Reference: 19/05000/HYB

Site: DSTL Fort Halstead Crow Drive Halstead Sevenoaks KENT TN14 7BU

Development: Hybrid application comprising, in outline: development of business space (use classes B1a/b/c) of up to 27,659 sq m GEA; works within the X enclave relating to energetic testing operations, including fencing, access, car parking; development of up to 750 residential dwellings; development of a mixed use village centre (use classes A1/A3/A4/A5/B1a/D1/D2); primary school; change of use of Fort Area and bunkers to Historic Interpretation Centre (use class D1) with workshop space and; associated landscaping, works and infrastructure. In detail: demolition of existing buildings; change of use and works including extension and associated alterations to buildings Q13 and Q14 including landscaping and public realm, and primary and secondary accesses to the site.

Connections – Existing Cycle and Footpaths

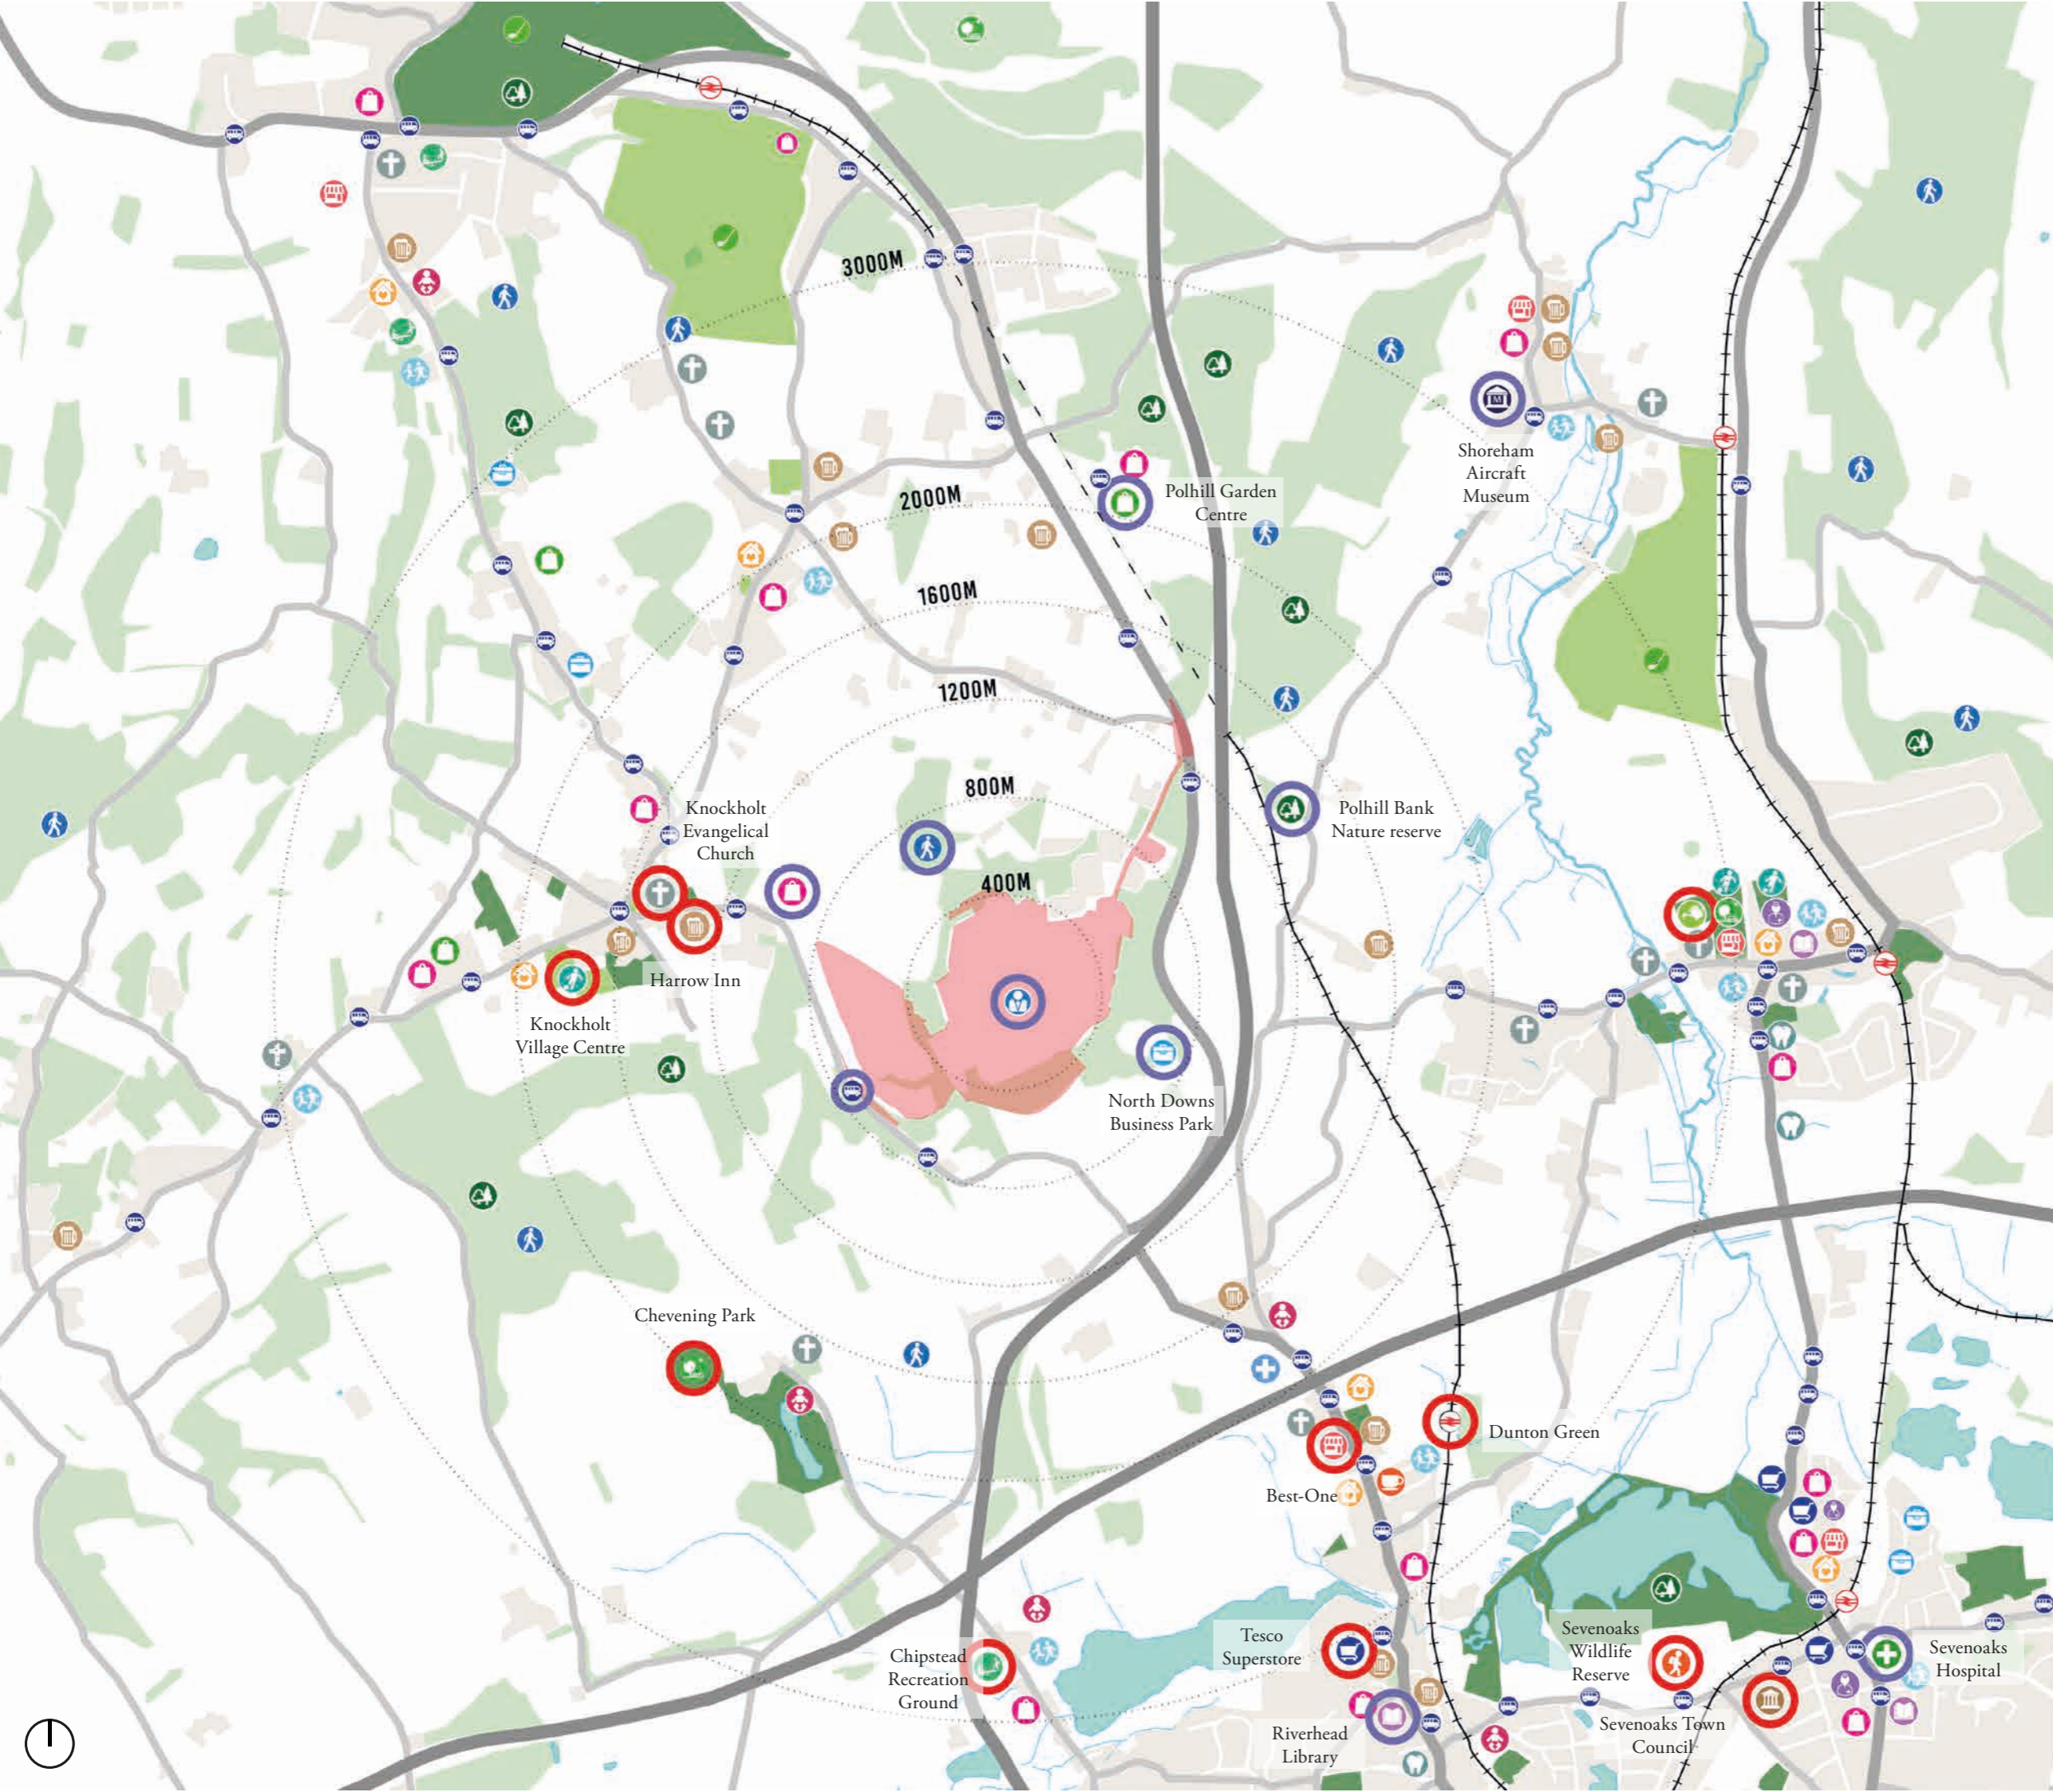
With reference to page 148 of the Design and Access Statement, the applicant has indicated a cycling route along the alignment of this right of way that would connect the development site with Otford Lane. While the creation of new off-road cycling access is supported, it is not clear how this proposal will be delivered, as the existing route is recorded as a public footpath and has a number of stiles that restrict access.

The status of the route will need to be upgraded to facilitate cycling, though considering the majority of this path appears to be located on land beyond the control of the applicant, it is not clear how this proposal will be achieved. It is therefore requested that the applicant engages with the KCC PRow and Access Service to clarify the details of their proposal.
